Our Reference: SYD14/00220/04 (A11714032)
Department Ref: SSD 6407

STAGED COMMERCIAL PRECINCT
185-195 FIFTEENTH AVENUE, WEST HOXTON

Pahee Rathan
Senior Land Use Planner
Network and Safety Section

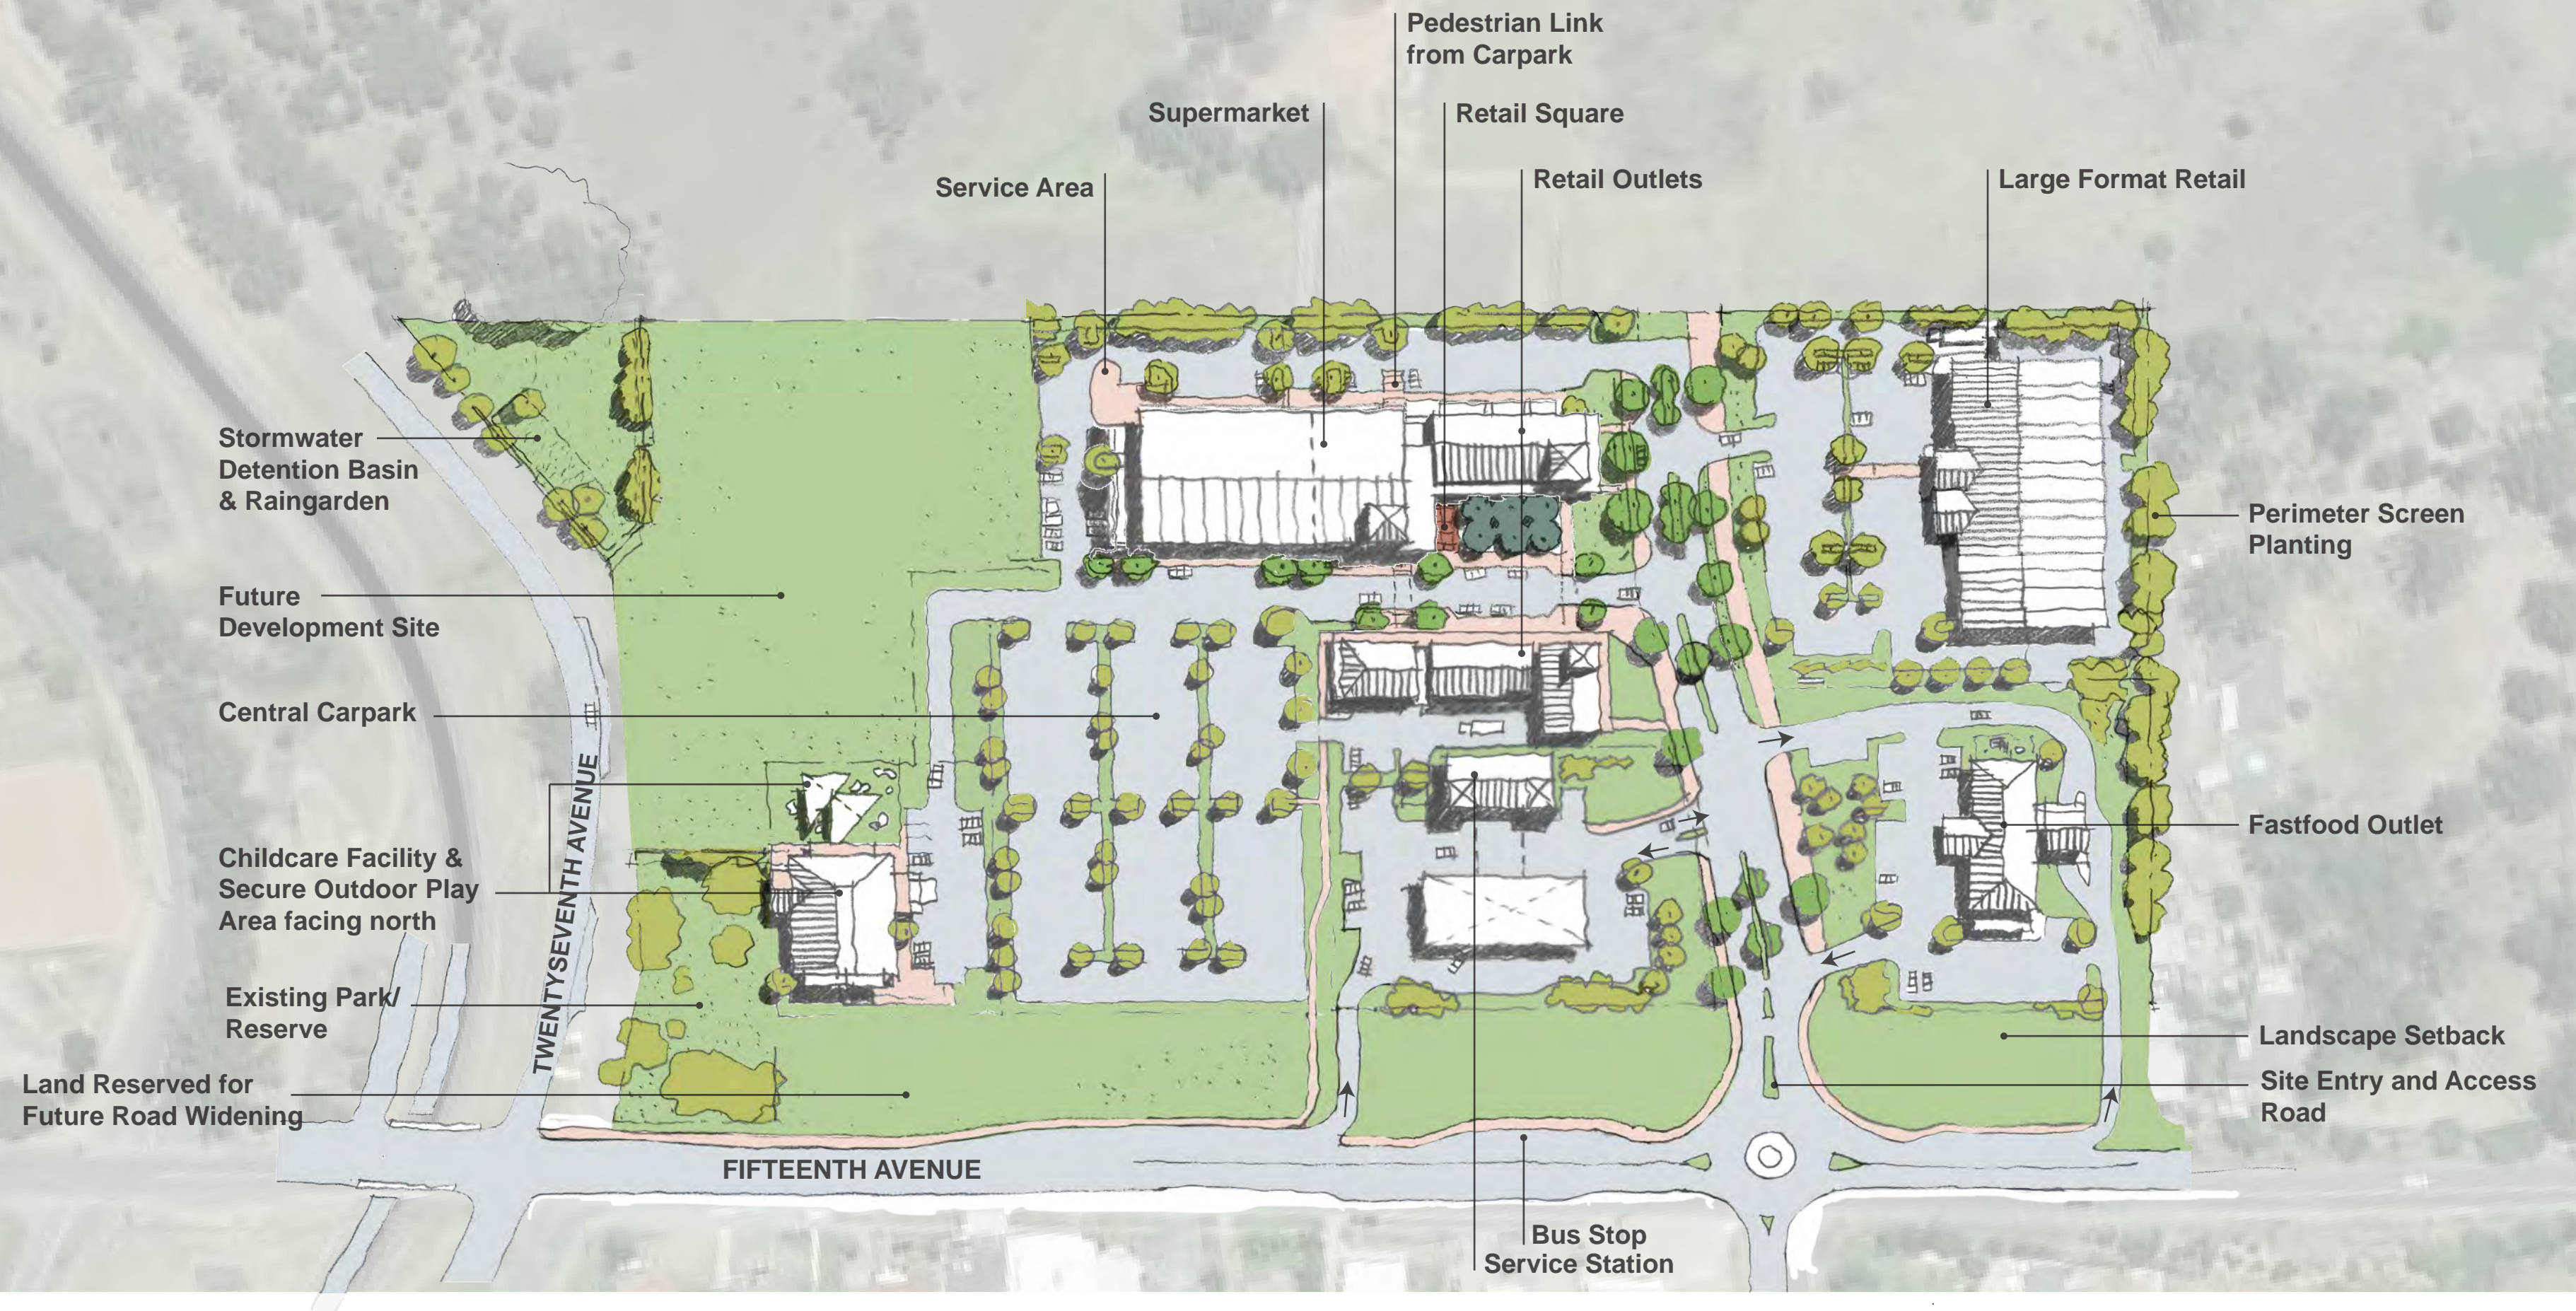
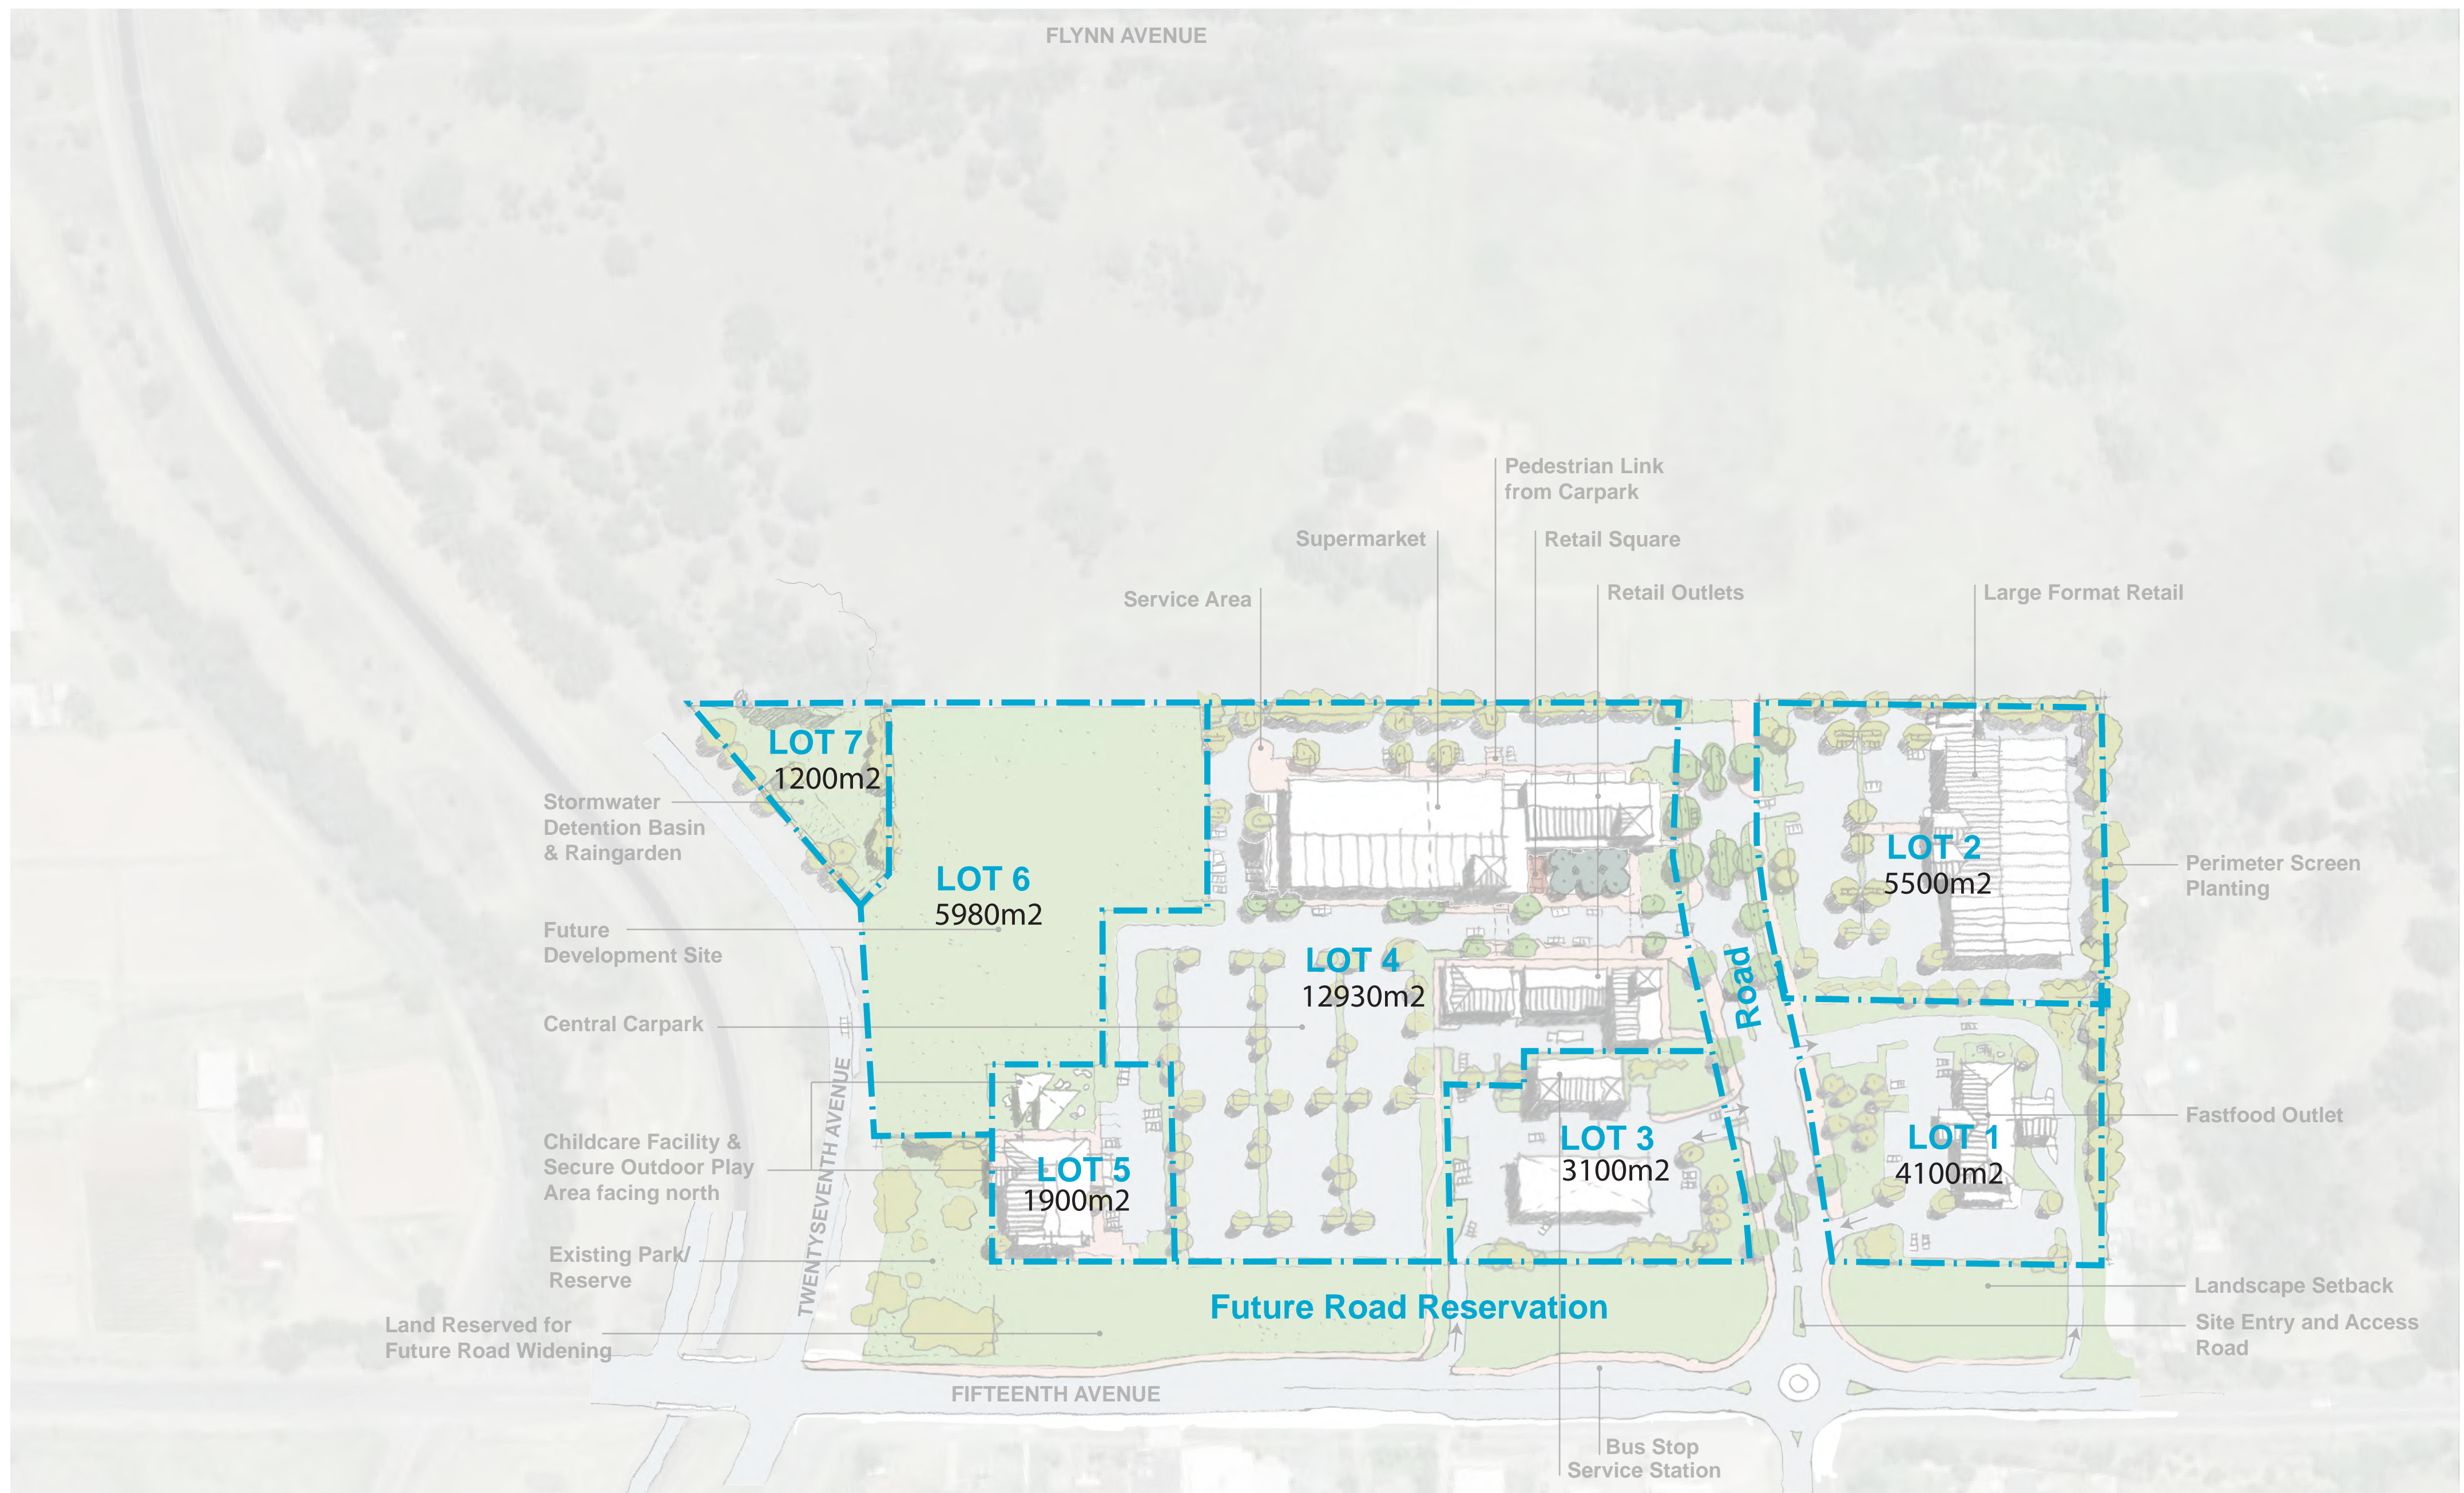
1. Access to the site from Fifteenth Avenue should be limited to that at the proposed roundabout and the deceleration lane to the service station. (The deceleration lane access into the Service Station is restricted as ingress only)
2. The planned bus stop provision will be required and designed to the appropriate standard. However, this will be removed at a later date once the road is upgraded. It is recommended

that the bus stop be located prior to the commencement of the service station deceleration lane and should be separated by chevron line marking.

3. The proponent should be advised that the planned roundabout is likely to be replaced by traffic signals when the road is upgraded.
4. A corridor of up to 43.2m would be required for the Transit Boulevard upgrade. This allows for the planned road corridor plus dedicated turning lanes into and out of the development when the intersection is signalised. The proposed development should be setback sufficiently to ensure any future buildings and substantial structures are erected clear of any land required for future road widening. Roads and Maritime would recommend a meeting with the Department of Planning & Environment and the developer to discuss the affectation in more detail.
5. When Fifteenth Avenue is widened, the fast food exit needs to be closed off and relocated further away from the intersection.
